From: Carmichael Ian [REDACTED]
Sent: 13 July 2020 08:30
To: GRAY Clare [REDACTED]
Cc: Planning [REDACTED]
Subject: Planning ref: 20/00934/FUL (AMENDMENTS). Land at Rear of The George Inn 5 Sandford Rd Littlemore Oxford OX4 4PU.

Planning ref: 20/00934/FUL (AMENDMENTS). Land at Rear of The George Inn 5 Sandford Rd Littlemore Oxford OX4 4PU.

Crime Prevention Design Advisor | Oxfordshire | Local Policing | Thames Valley Police

Land to rear of George Pub Littlemore	Date:	01/10/2020
KJD Investments	Scale:	1:100@A3
Units 6 & 7	Status:	Preliminary
Proposed Elevations	Drawn:	JR
190277 - A - 05 - 203	Revision:	C

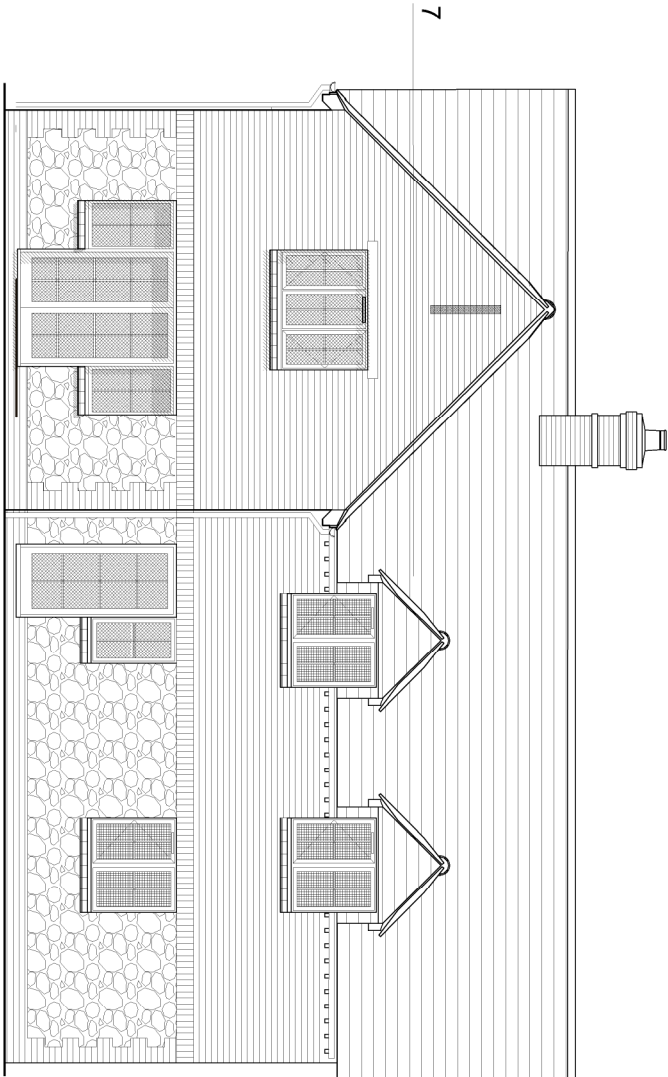
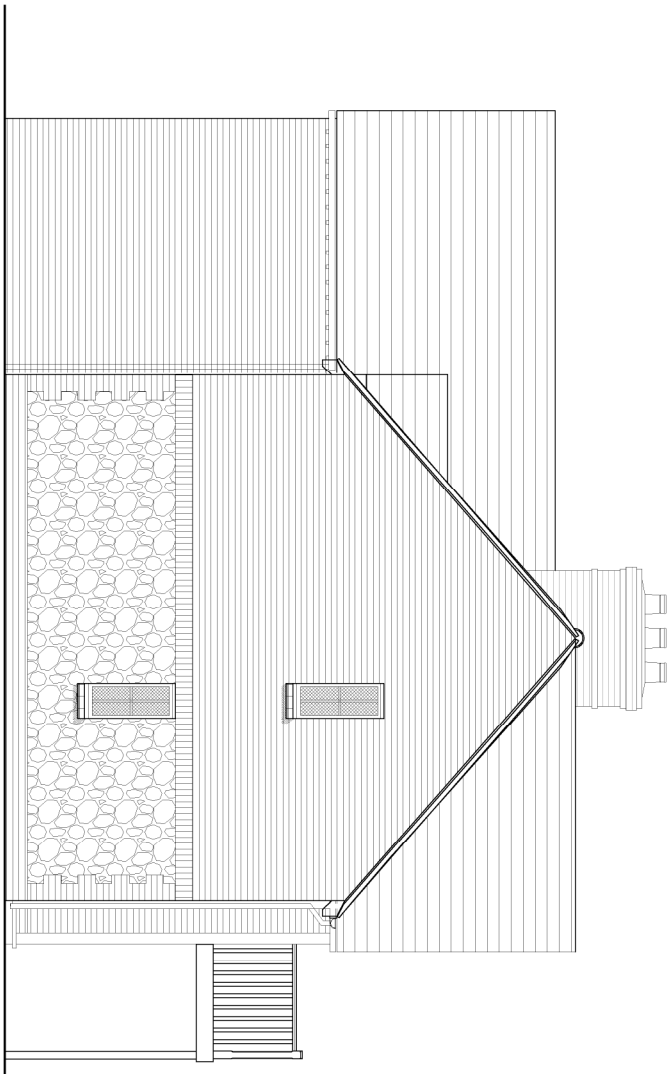
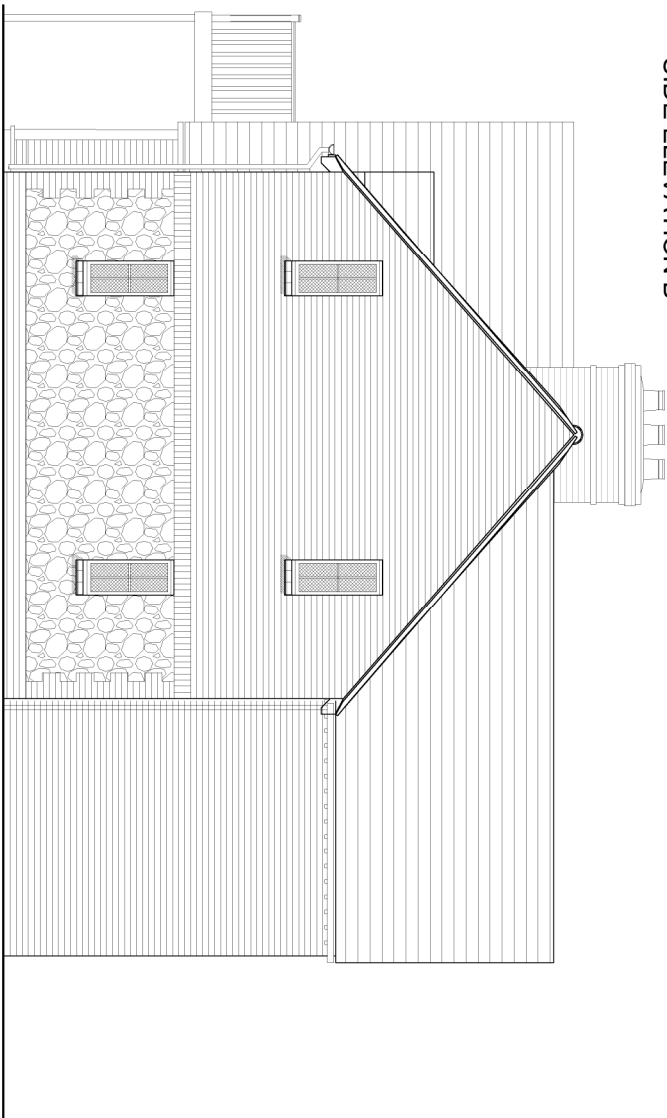
- There is very little natural surveillance from any of the dwellings over any part of the access or parking. I recommend that the internal layout of dwellings is revisited with a view to providing more windows of active rooms overlooking these spaces to remedy this situation. Active rooms include living rooms, kitchens and hall ways. Studies, bedrooms, bathrooms/toilets etc. are not considered active. Side elevation windows of active rooms must be provided at Plots 1 and 3 regardless.
